CITY OF ALBUQUERQUE

June 6, 2024

Re: McDonald's
5900 Menaul Blvd. NE
30-Day Temporary Certificate of Occupancy
Transportation Development Final Inspection
Engineer's Stamp dated 09-11-23 (H18-D070)
Certification dated 05-29-24

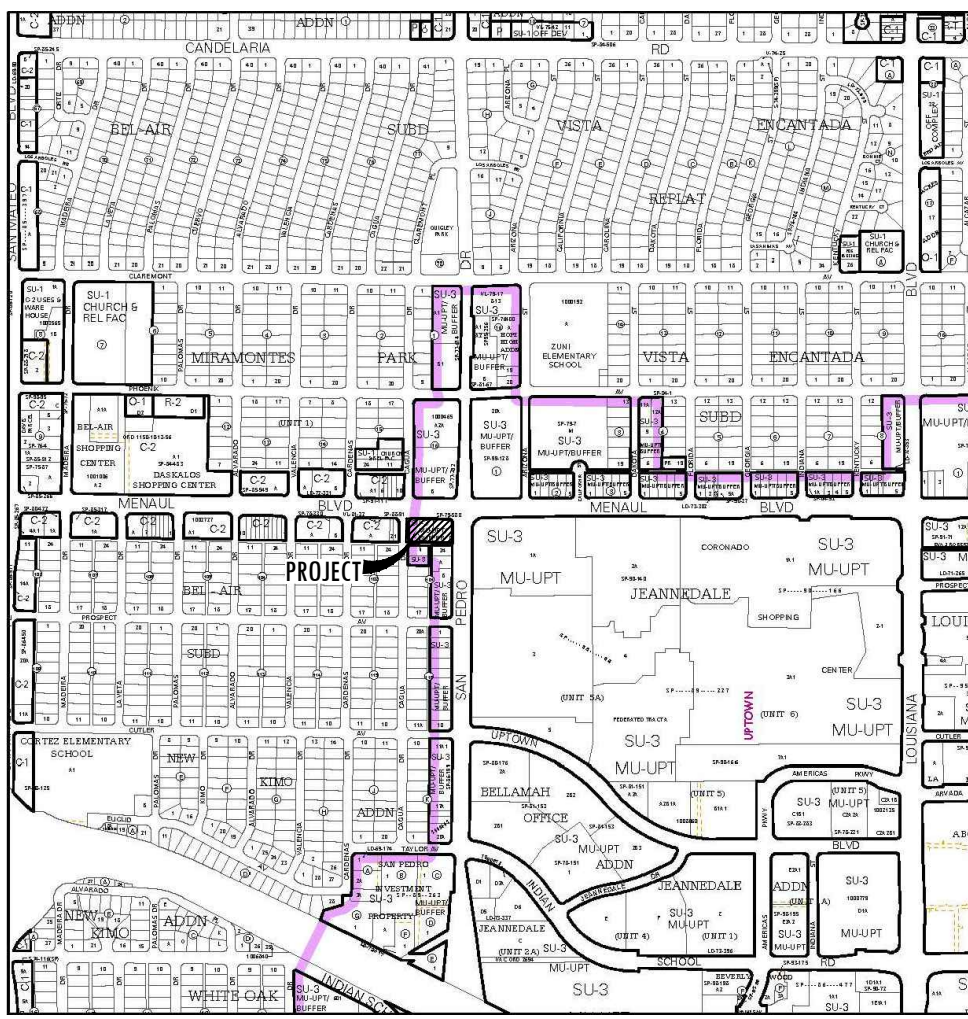
2. Provide "MC" pavement marking, the pavement marking "MC" should be shown in the opposite direction for motorcycles entering the parking space.

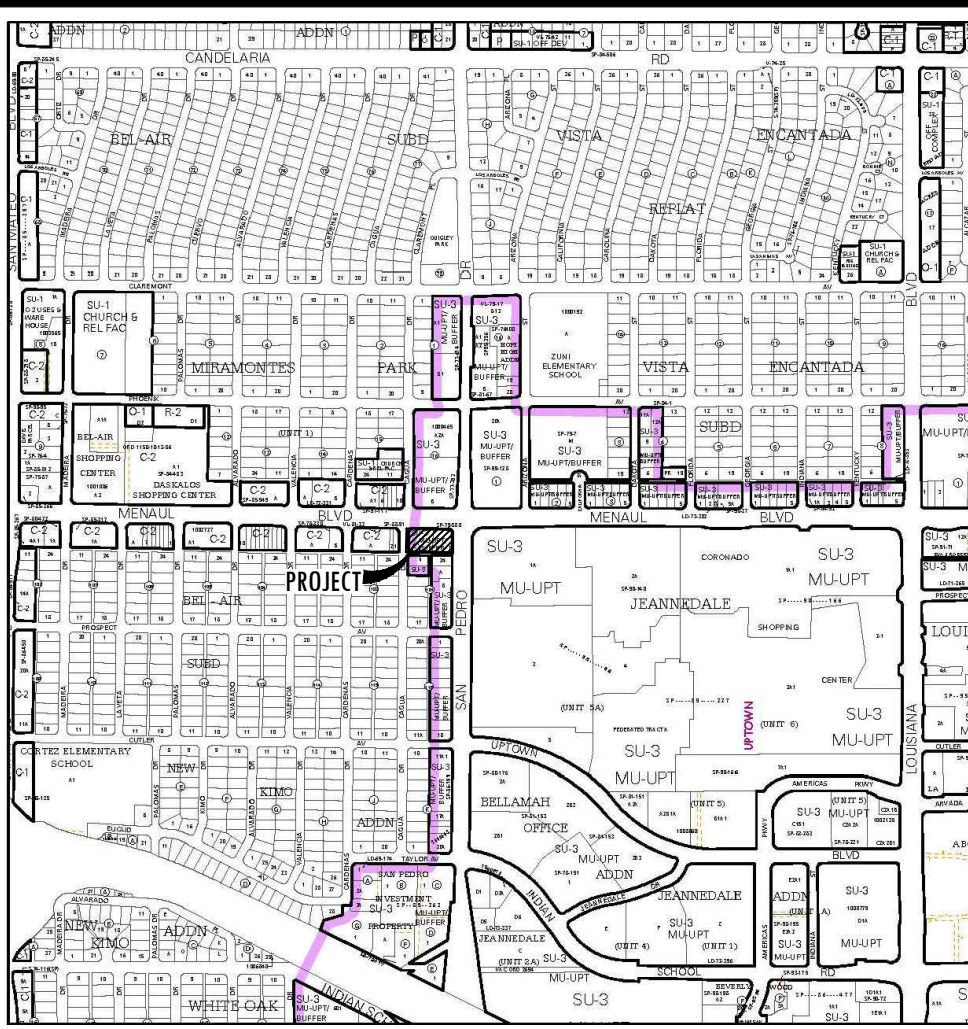
1. Sidewalk Easement is required prior to issue a Perm CO.
